KITITAS COUNTY

MEMORANDUM

TO: All Staff
FROM: Public Works Planning Review Team
DATE: March 3, 2020
SUBJECT: County Survey Review of BL-19-00023 Brunner

BRUNNER PROPERTY

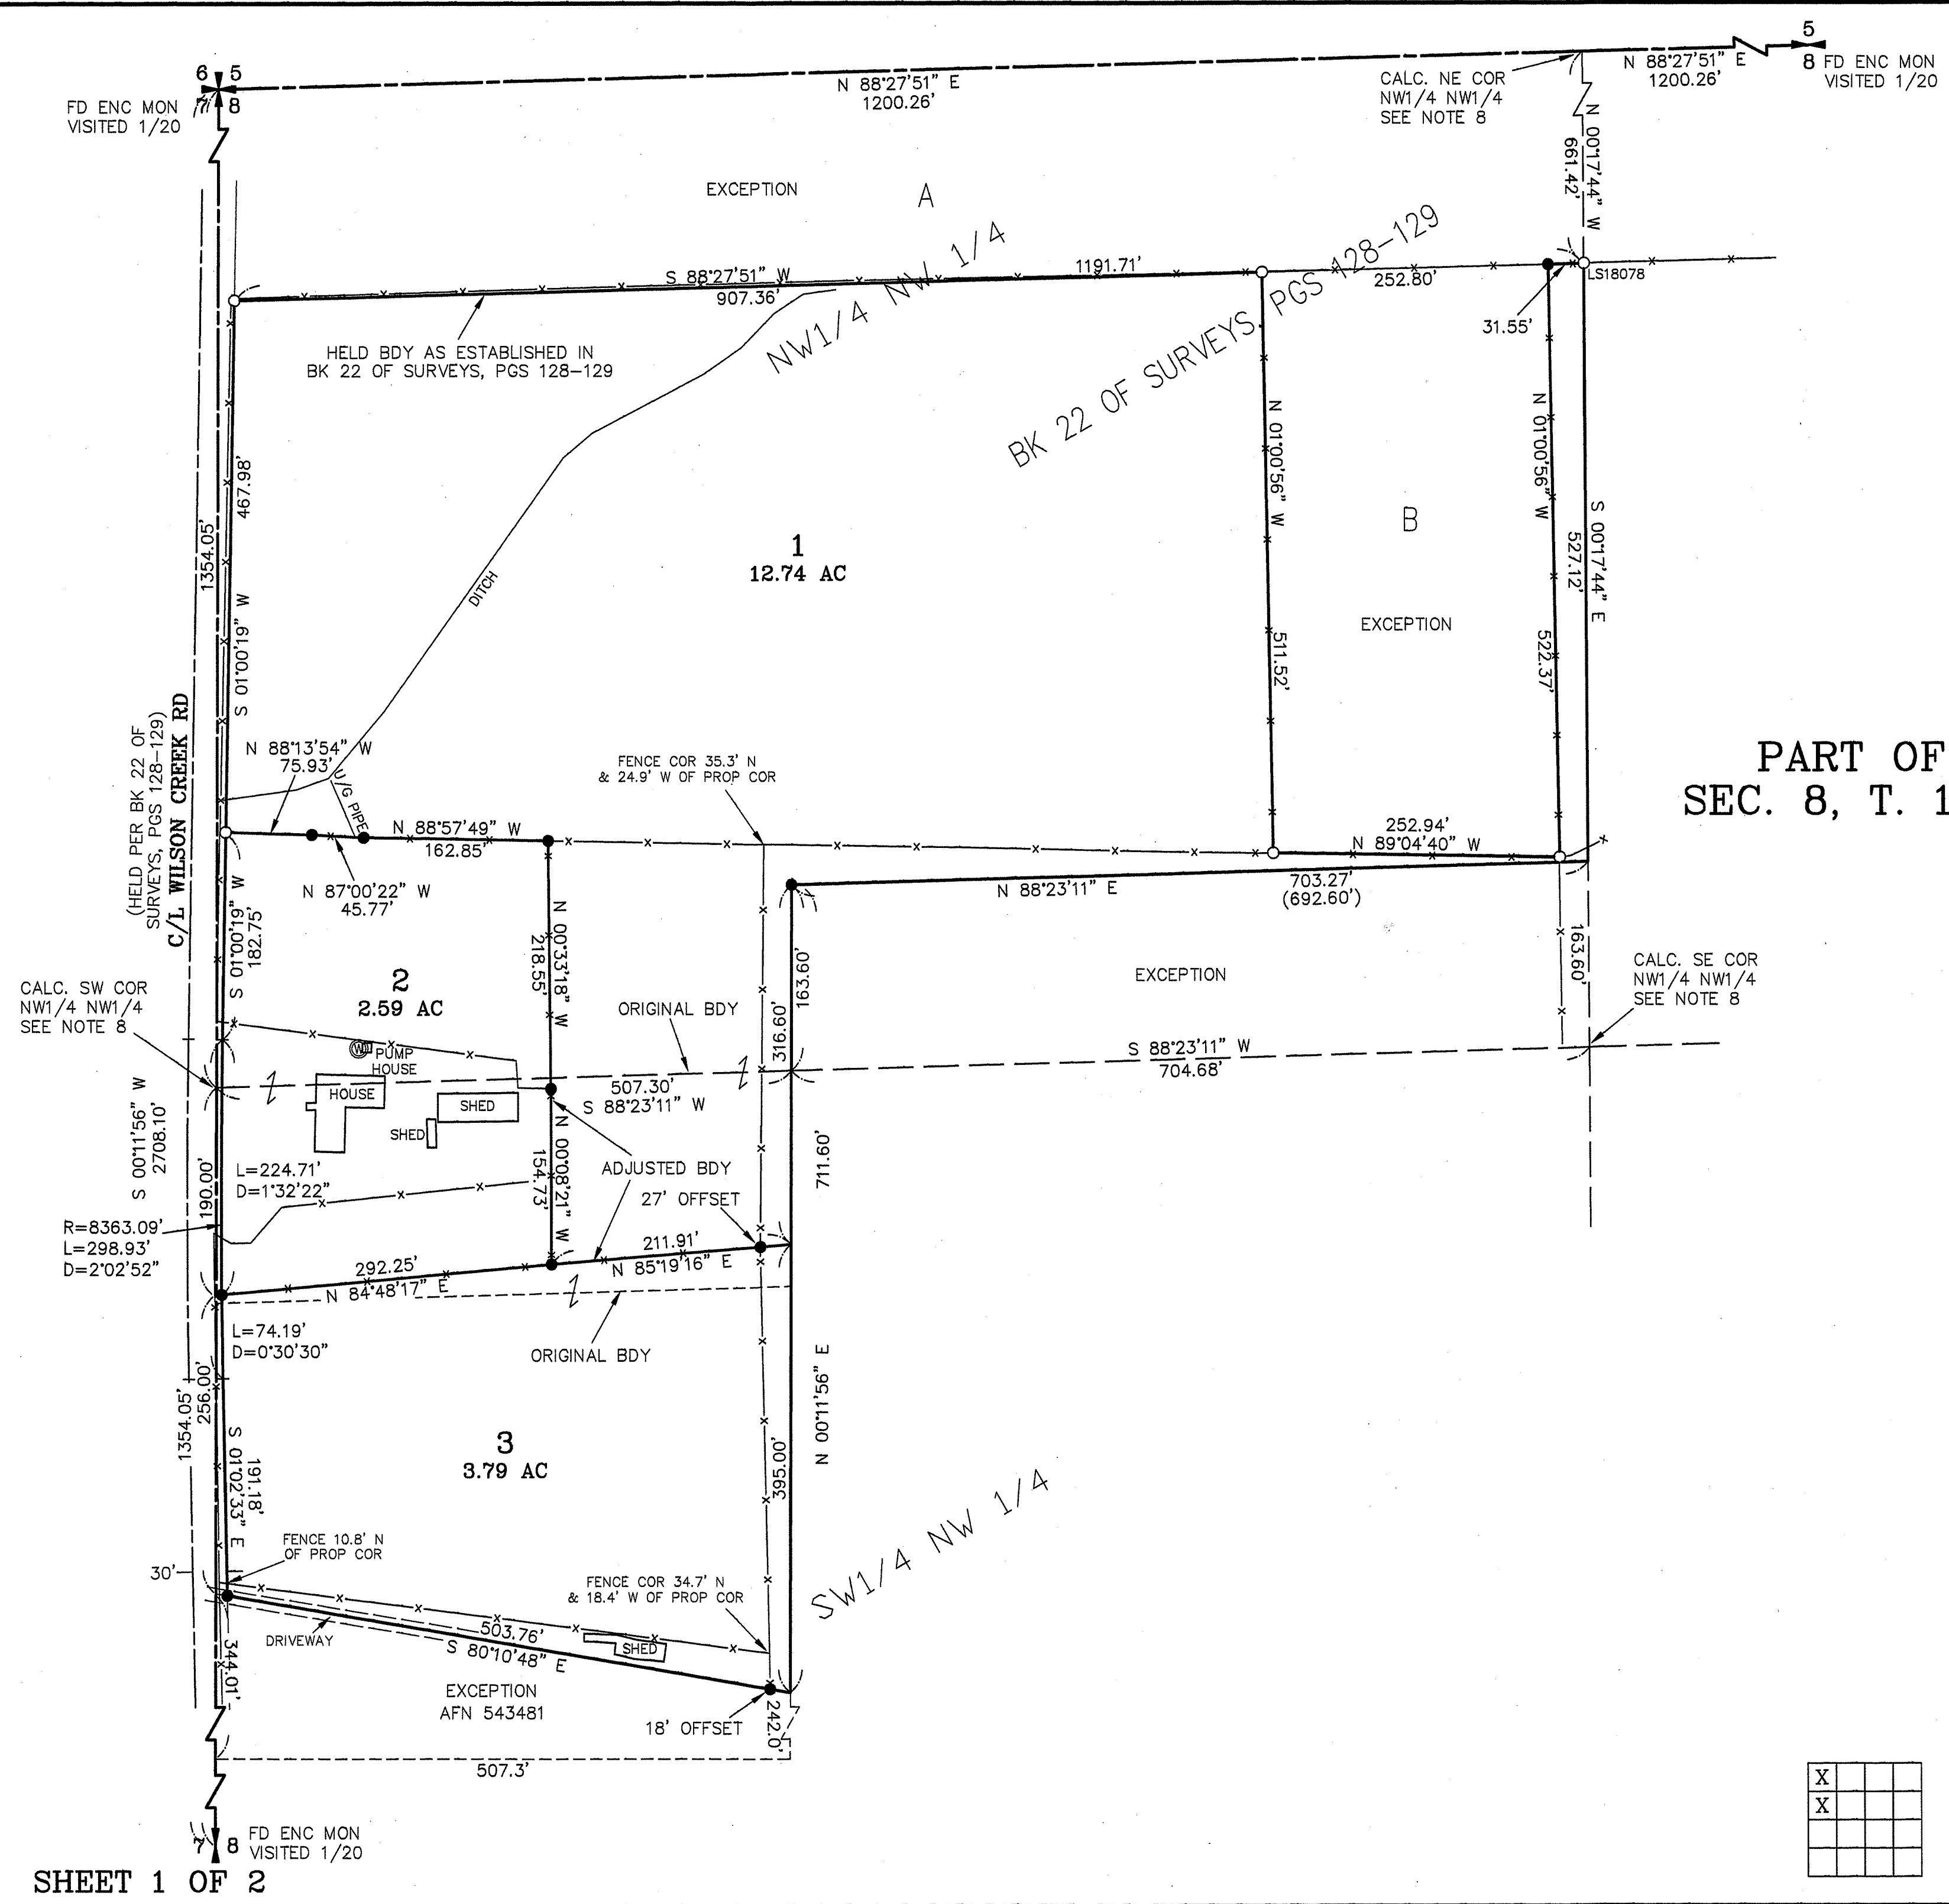
1. Wilson Creek Road should include ownership and paving details (county-paved).
2. The south line of Parcel 2 does not match closure report (17" vs 12"). Even with the differences, the values shown still meet closure requirements.
